SITE DEVELOPMENT PLAN

HONOR CHARTER SCHOOL
HIGHMARK SCHOOL DEVELOPMENT
8250 BENT GRASS MEADOWS DR.

S-1
OF
48

**ELEVATIONS GENERAL SHEET NOTES**

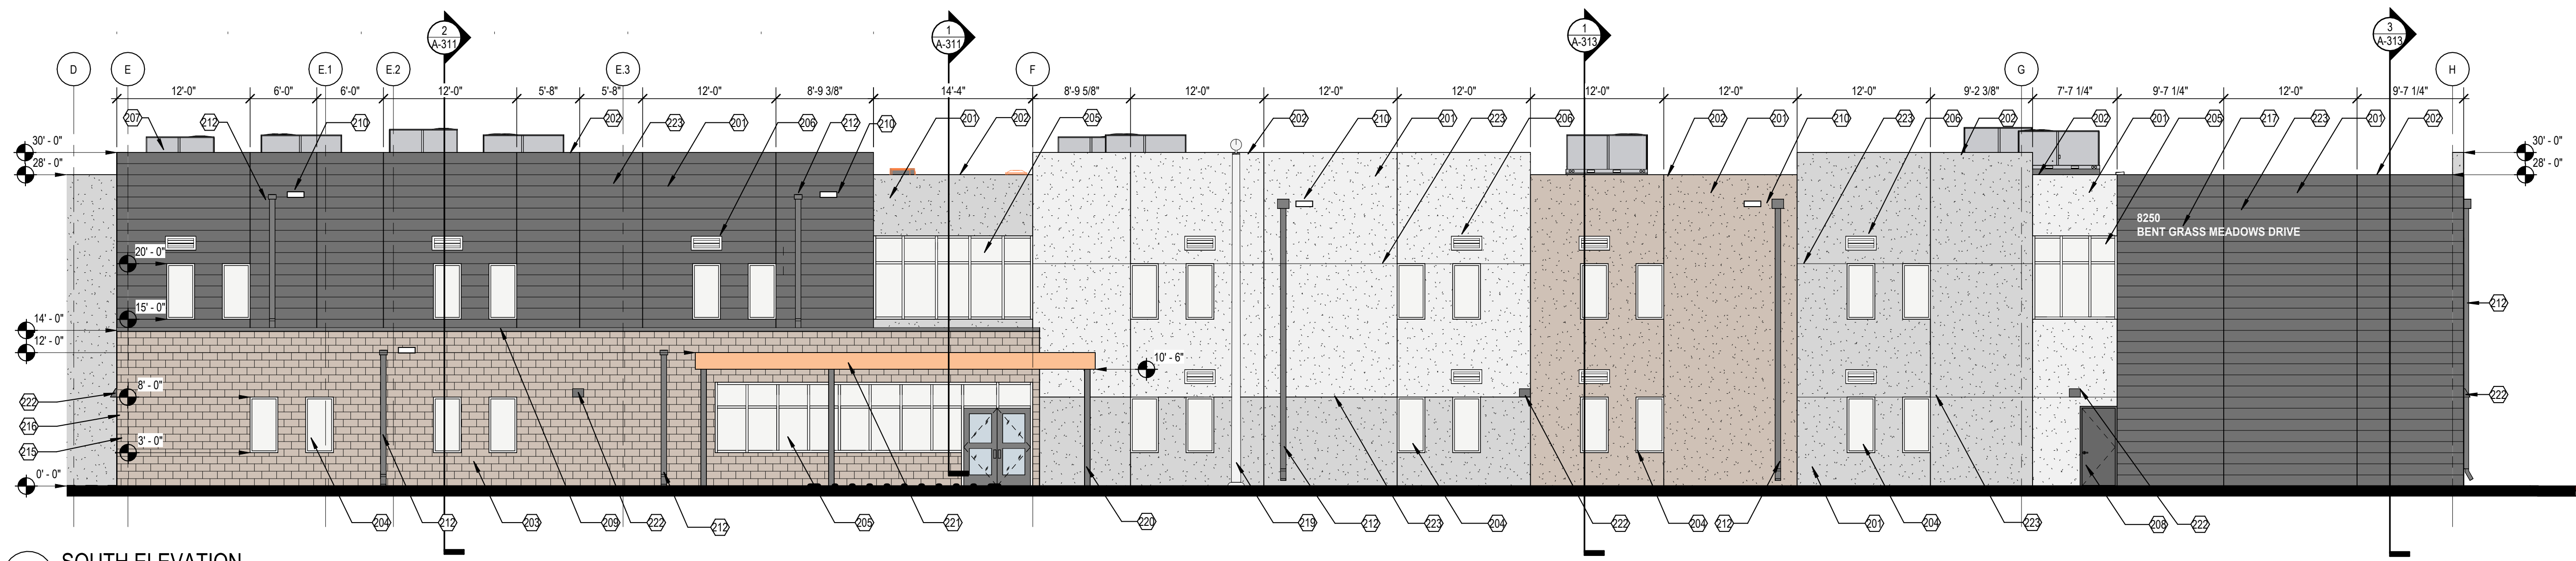
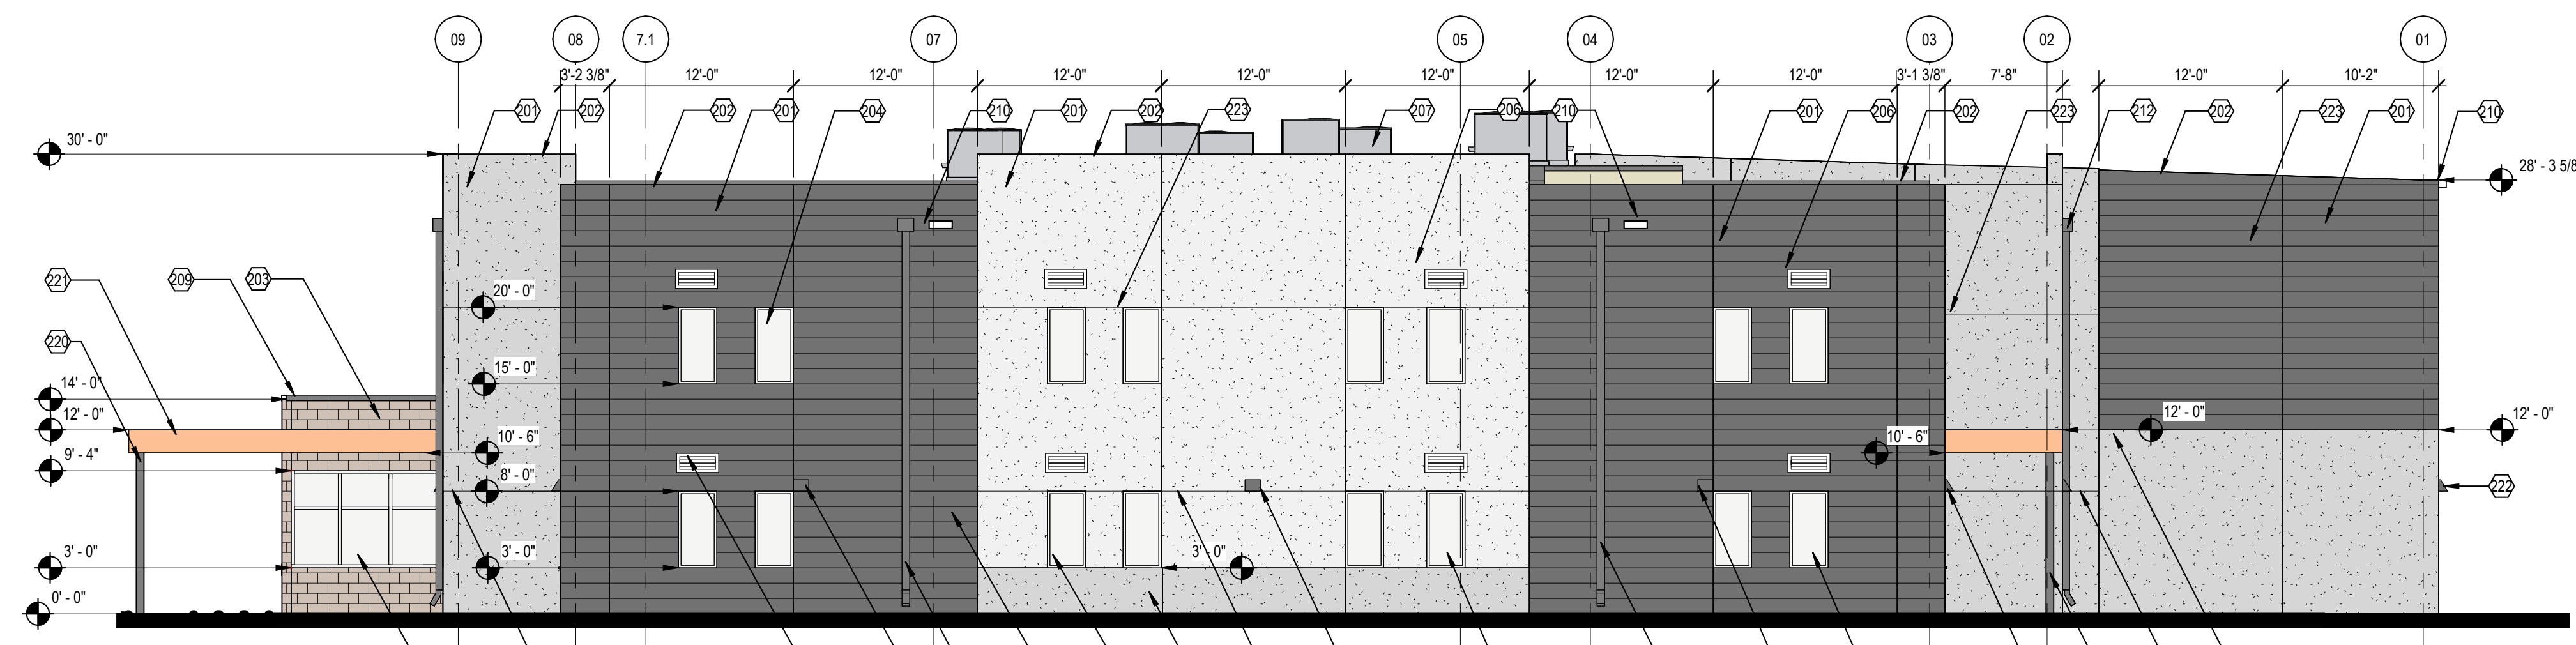
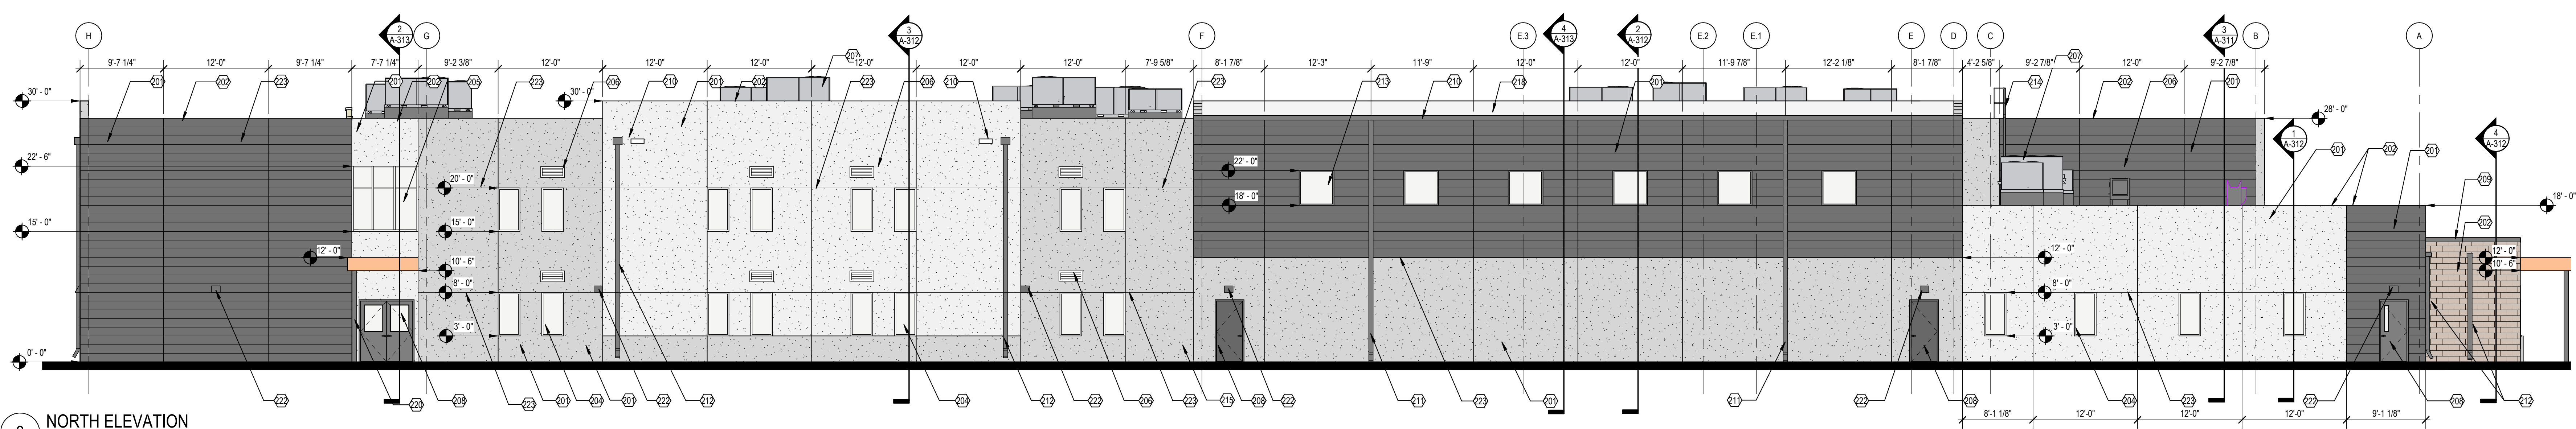
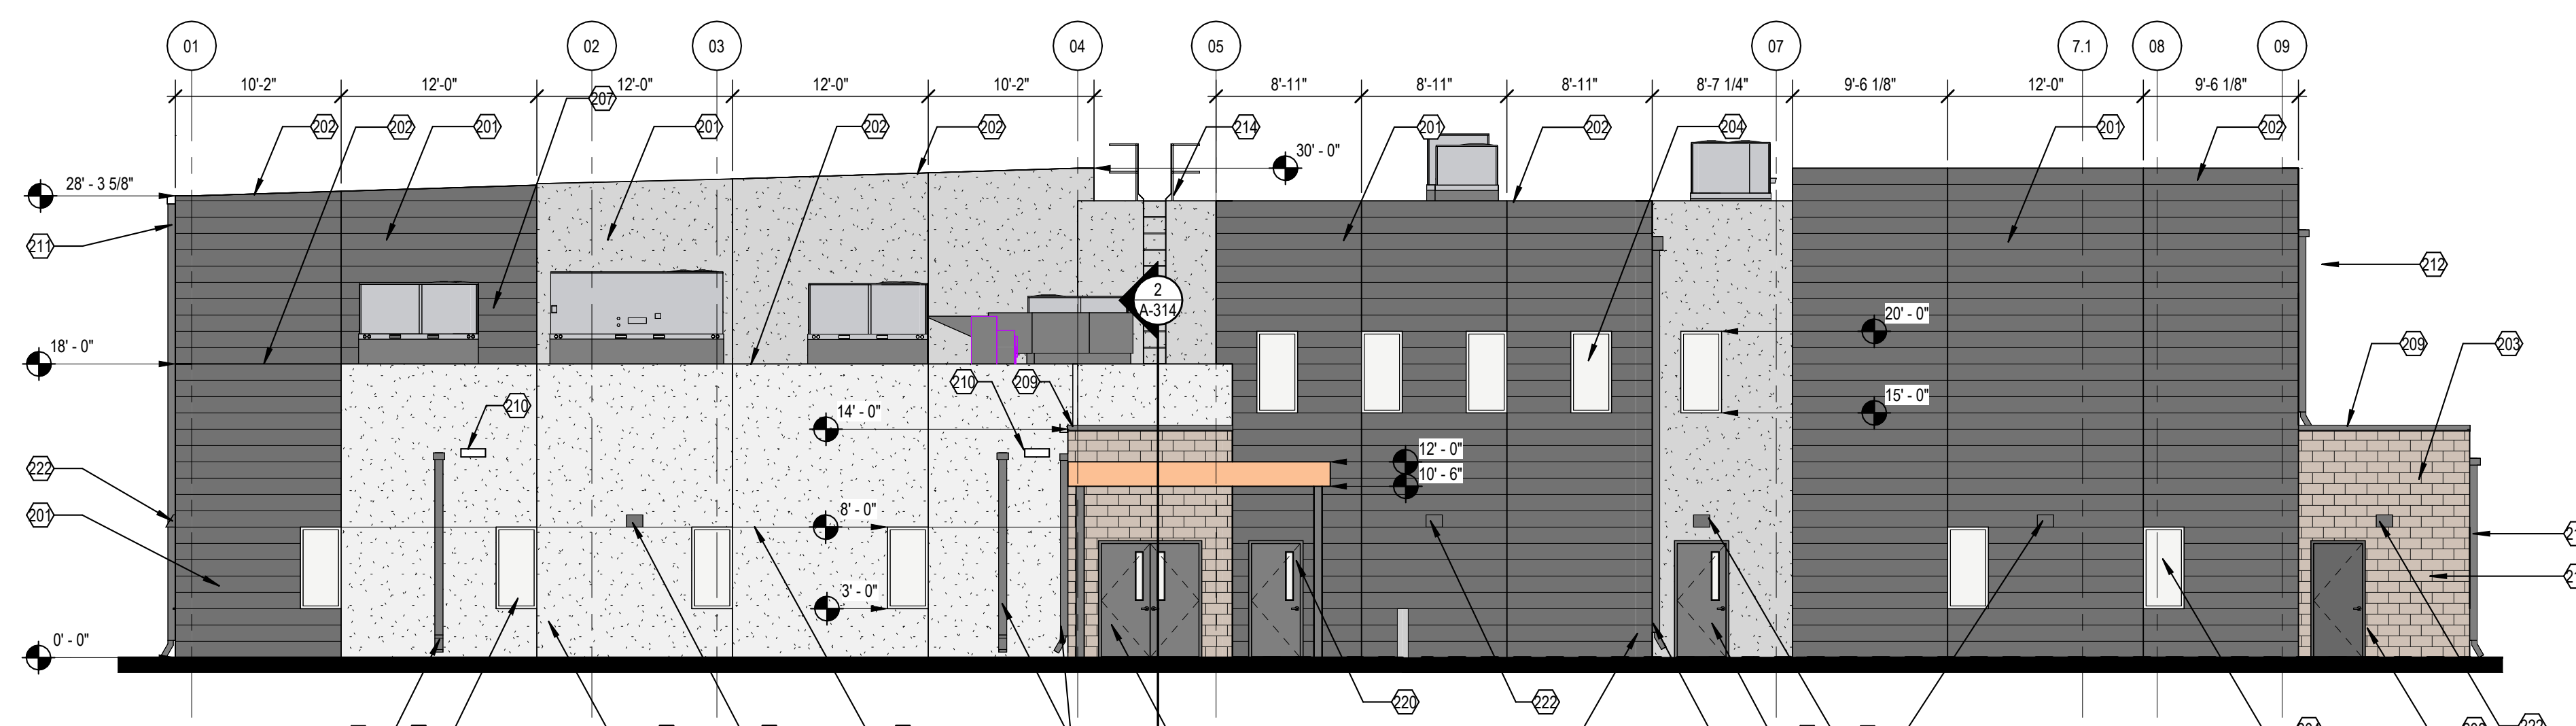
Action Item: Gas meter locations on plan view and building elevations must be shown and labeled.

Action Item: Add note " Gas meters must be a minimum of 3-feet from doors, operable windows, or any vents or openings in walls."

Action Item: Add note "CSU Field Engineer to determine final gas meter, and service line locations. Contact Field Engineering at 719-668-4985 (Gas)with any questions."

RESPONSE: CHANGES MADE TO BUILDING ELEVATION PLANS PER COMMENT.
